# Markup Summary

SF-18-041

SETTLERS VIEW SUBDIVISION

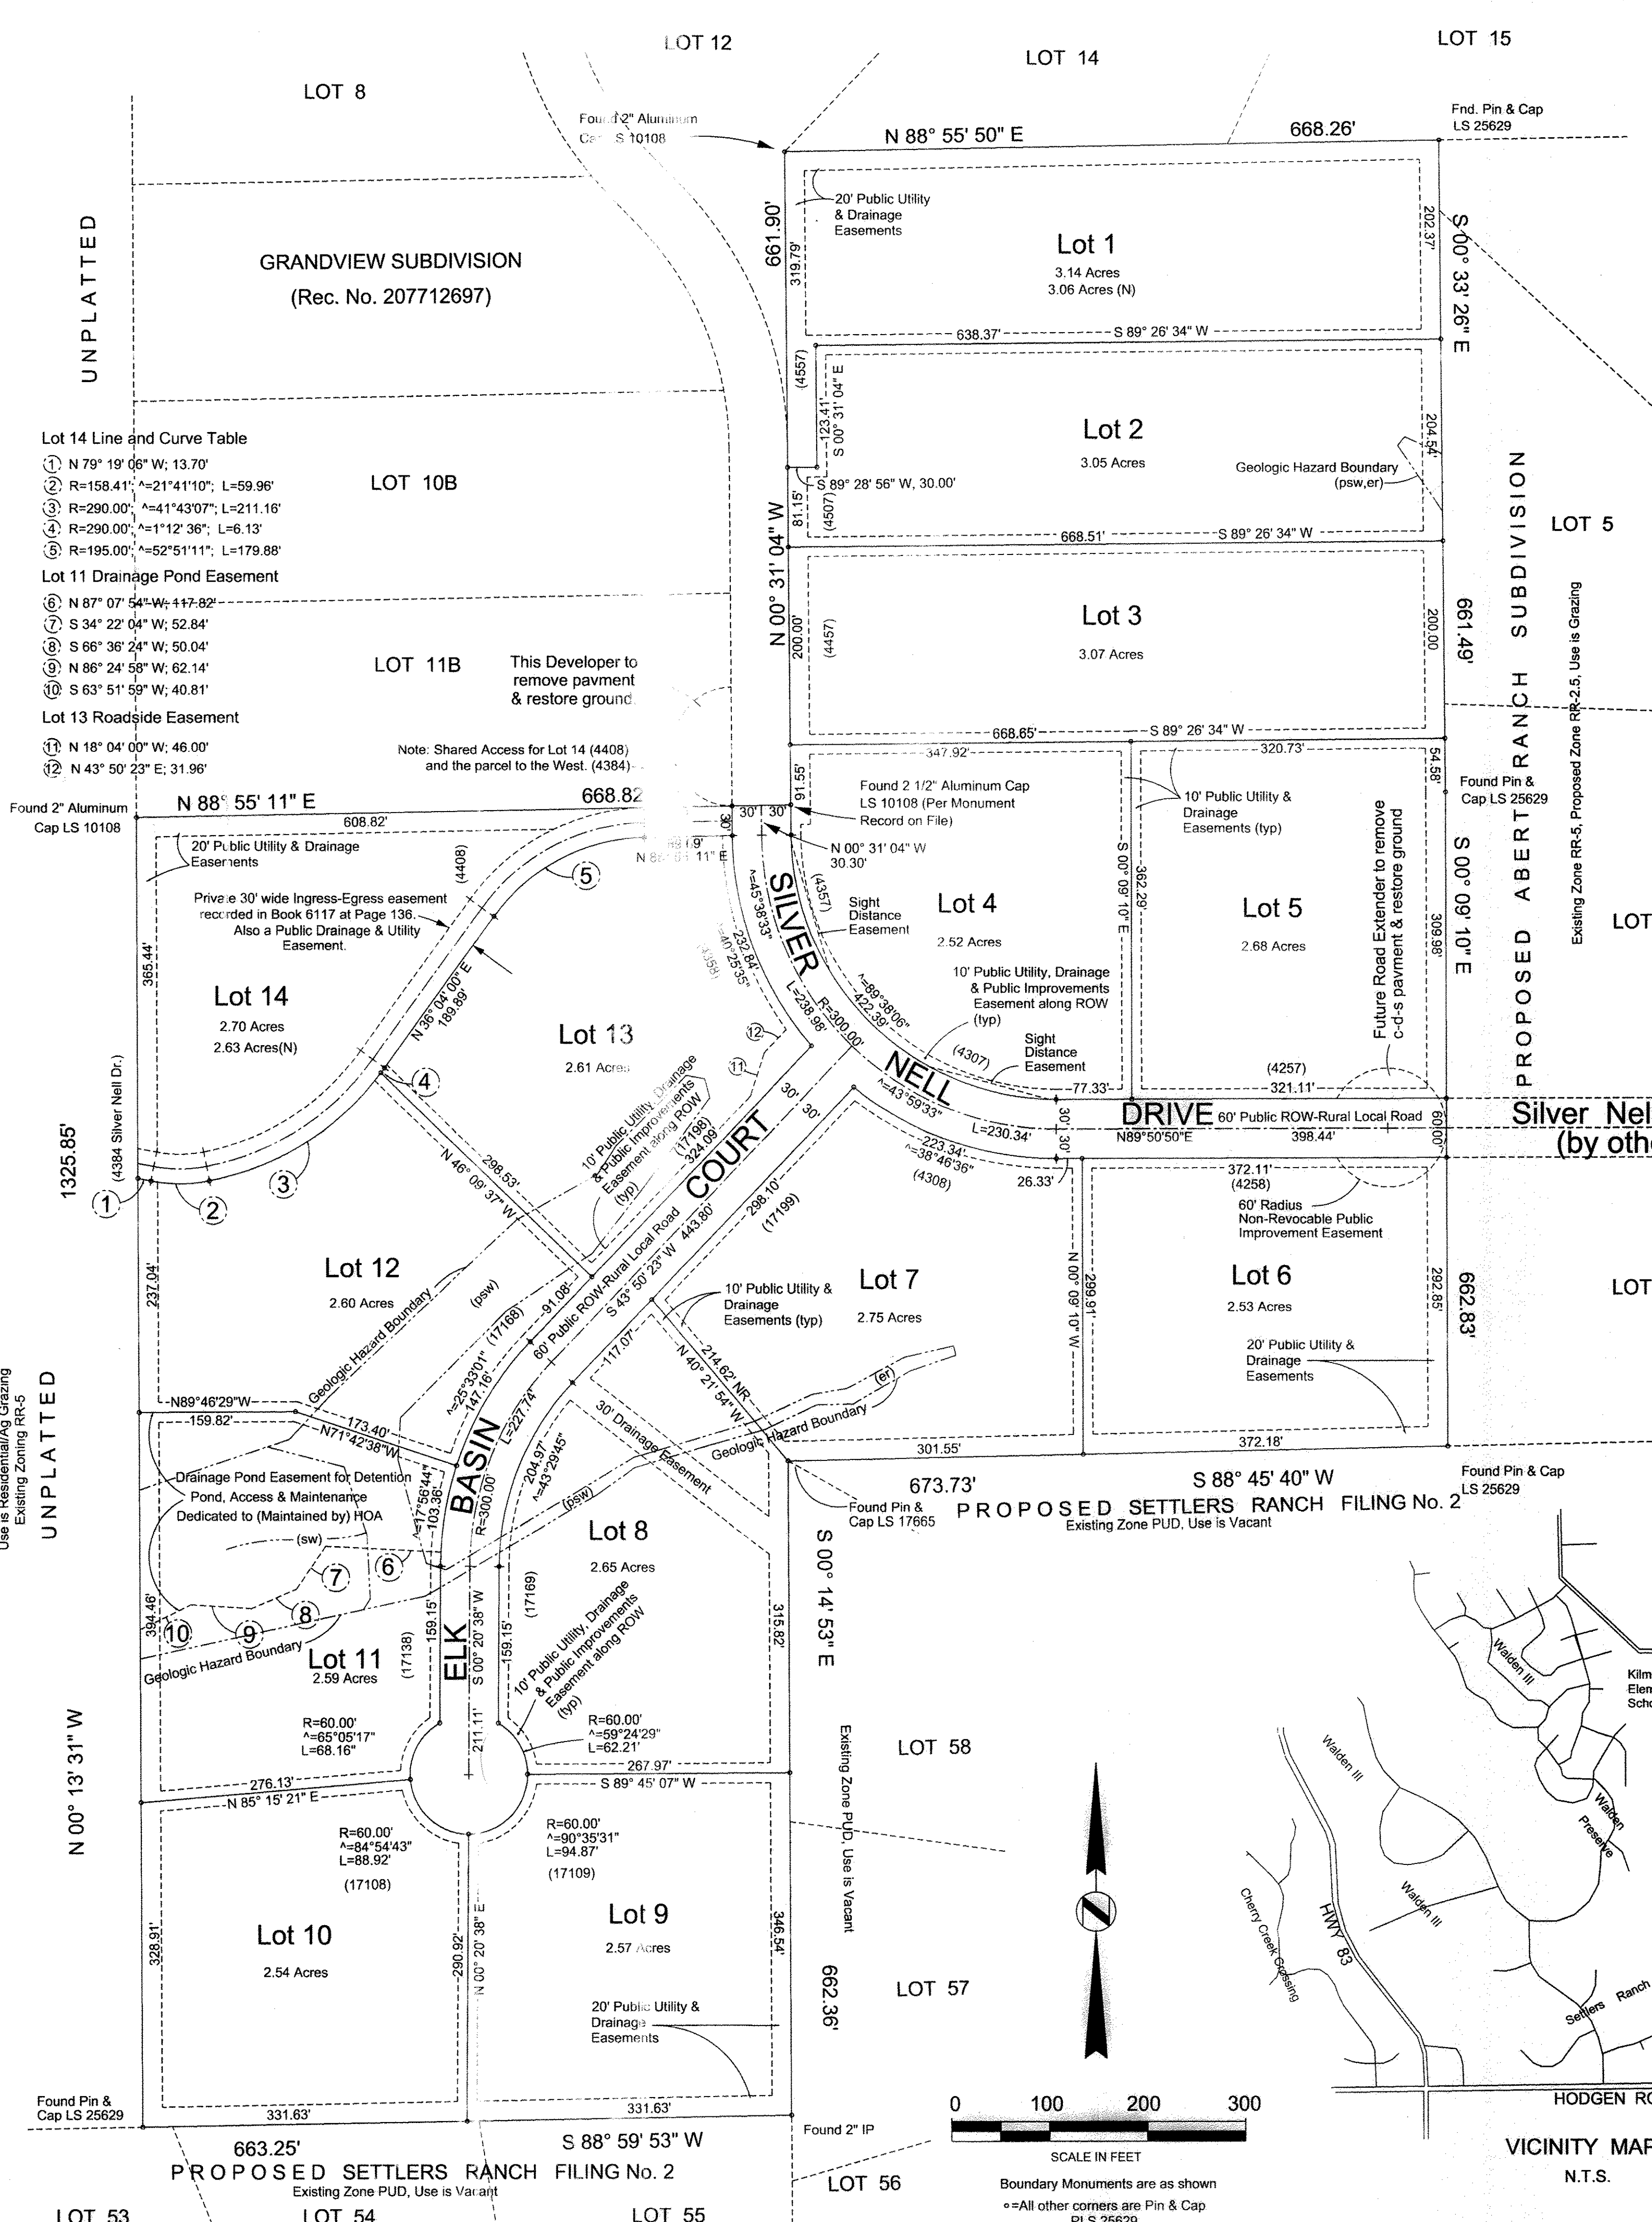
Provide Easement bearing and distance information.

Identify as a shared access for the property to the west and Lot 14.

A private maintenance agreement is required. Add a plat note referencing the reception number for the recorded agreement.

Update note 10 to identify if the impact fee is paid in full or if the developer is requesting to be included in PID 2 or PID 3.

Insert the following after the first sentence in note 4 (Last sentence also remains): "Public drainage easements as specifically noted on the plat shall be maintained by the individual lot owners unless otherwise indicated."

Add the following note:

Revise to the latest FIRM Map: 08041C0305G  
revised December 7, 2018

Revise note to "60' Radius Non-Revocable Public  
Improvement Easement"

Add note and depict areas that need to be placed  
in the no-build or drainage easement. Septics  
should not be in these areas.

What is this note referring to?

Drainage easement?

Who is removing this and re vegetate remove

This should be public and then vacated when adjacent plat moves forward. That project seems to be on indefinite hold. Identify who will remove / re-vegetate the culdesac.

Add note to notes section who is responsible for maintenance of this on Lot 14.

Can you ghost in the roads so the overall connectivity is clear on Vicinity?

Revise with new resolution No.

Add the standard plat notes.

Add what zoning this is, utility providers, SIA note, water, sewage disposal, etc..

Correct Owners certificate and Add dedication statement
